August 6, 2013

Subject: Hillcrest Avenue Street Extension/Single Family Home  
Letter of Correspondence #1

This letter is in response to review comments contained in your letter dated July 29, 2013.

Drawing Name:	Details
Project:	Hillcrest Avenue Portland, Maine
Client:	Timothy Higgins 83 Bay Street, Portland Maine 04104

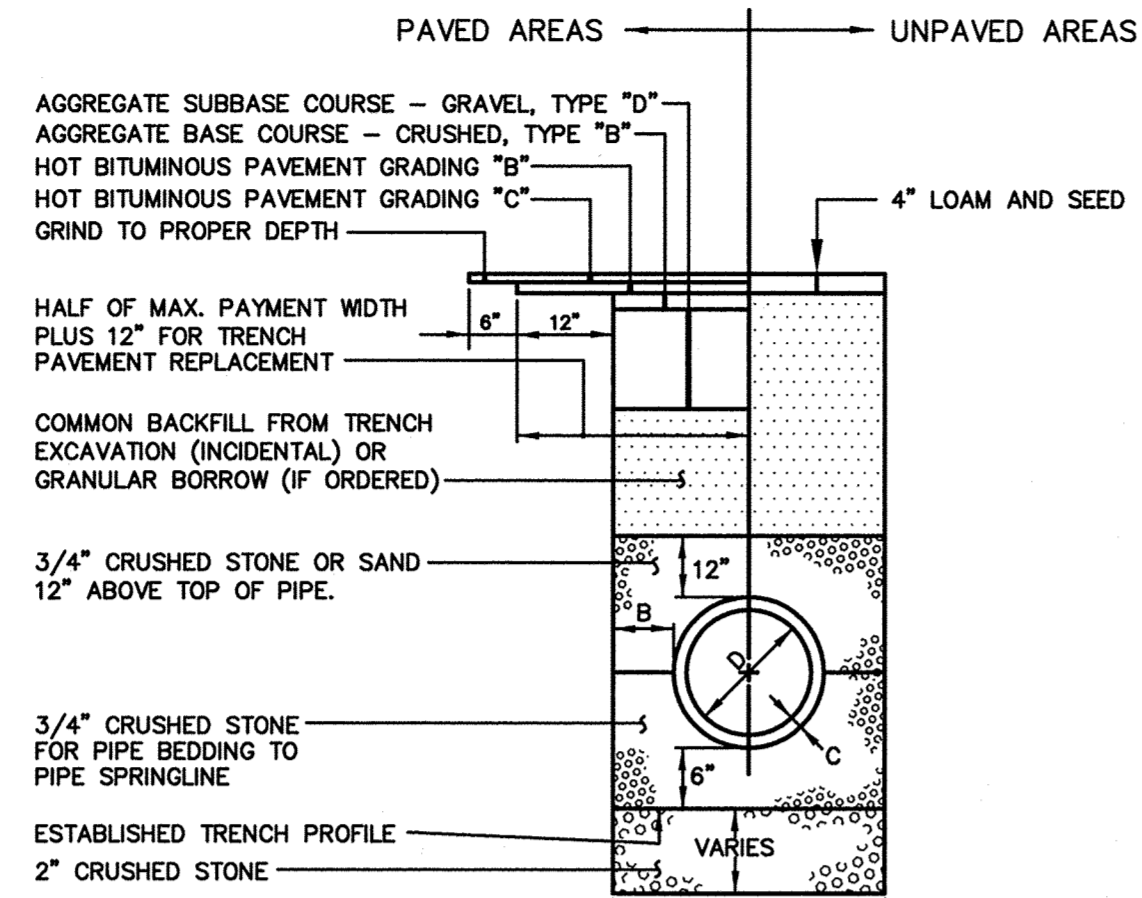
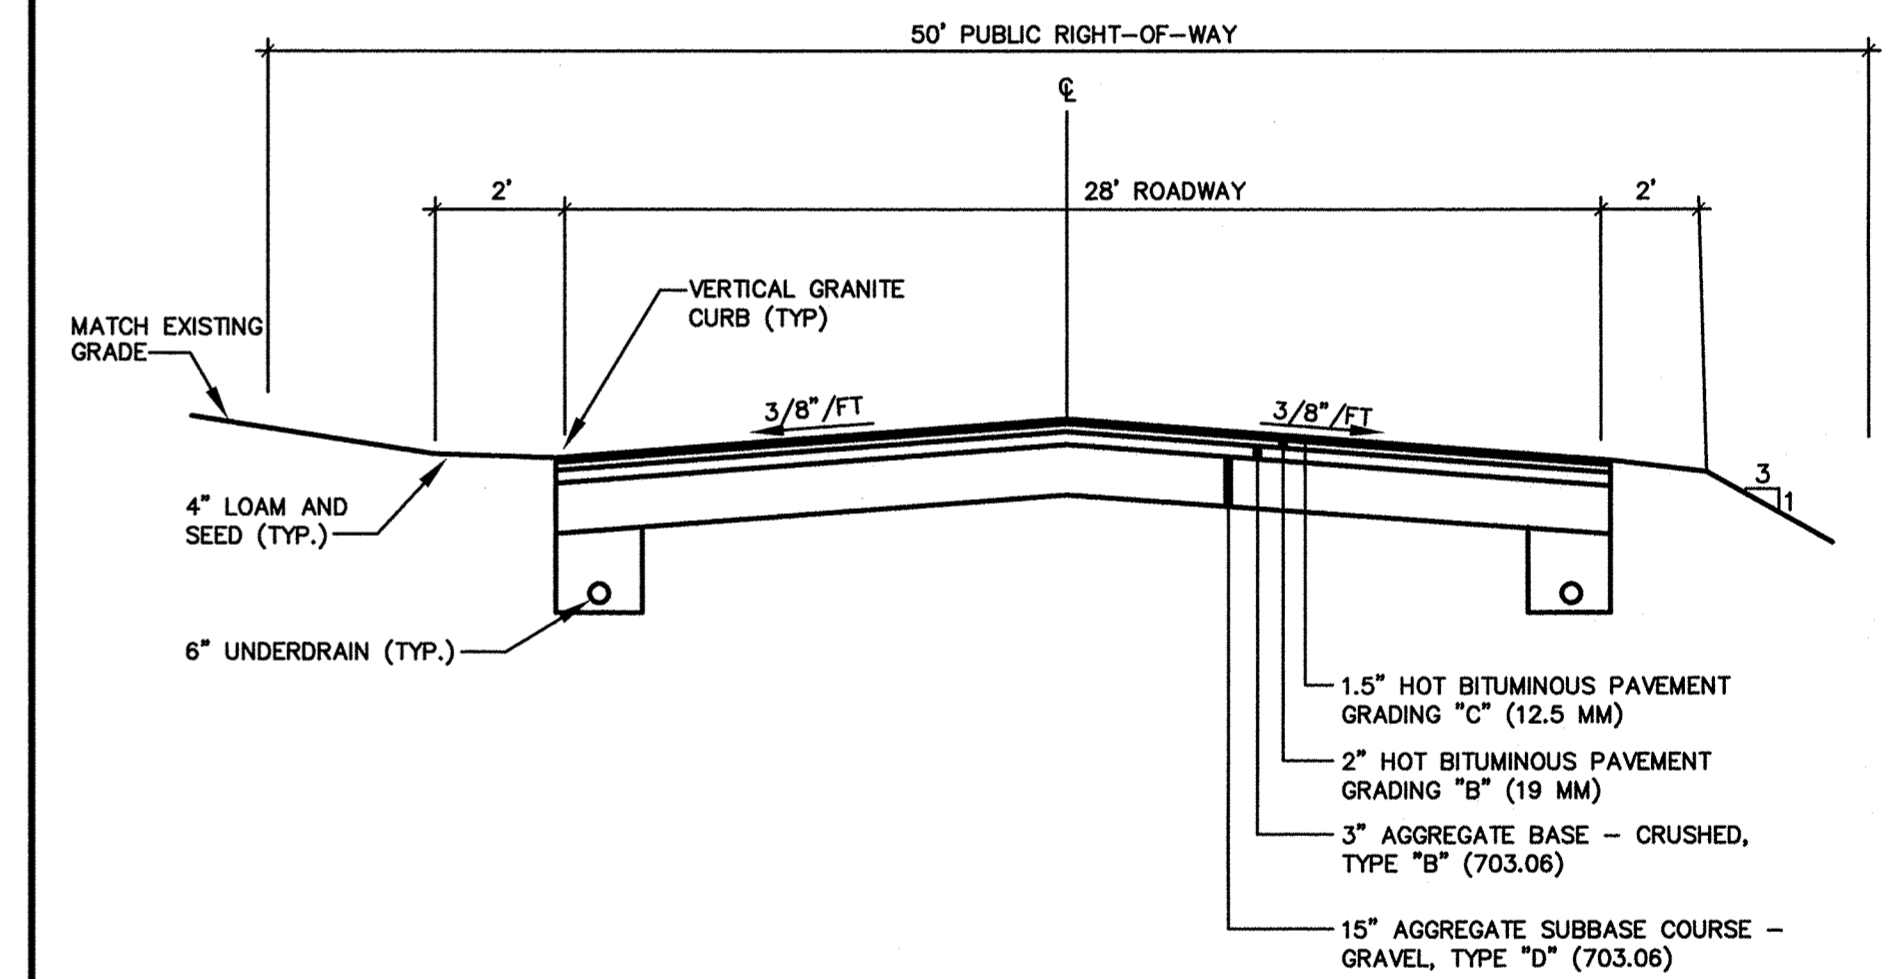
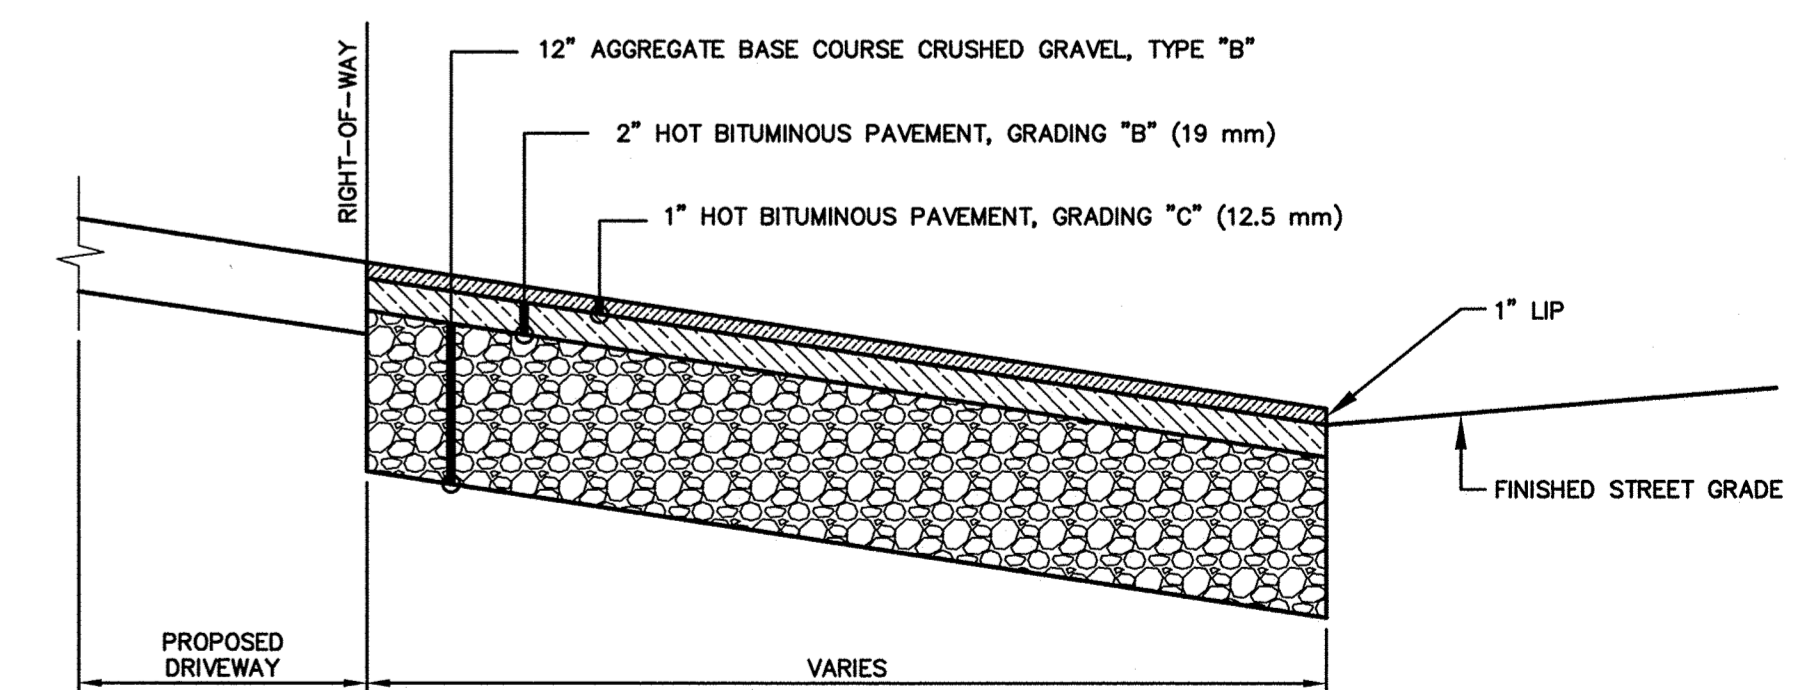
- 3. The Applicant has requested a waiver from the requirement to install underdrains within the proposed street, as the existing, unaccepted and private portion of Hillcrest Avenue does not appear to have underdrains. DPS will need to provide a determination on this waiver request. If the waiver is granted, the Typical Residential Roadway Cross Section detail should be revised to not include underdrains. Note that the Department of Public Services has indicated that they are willing to waive the underdrain requirement.*

**Response:** The underdrains have been removed from the detail.
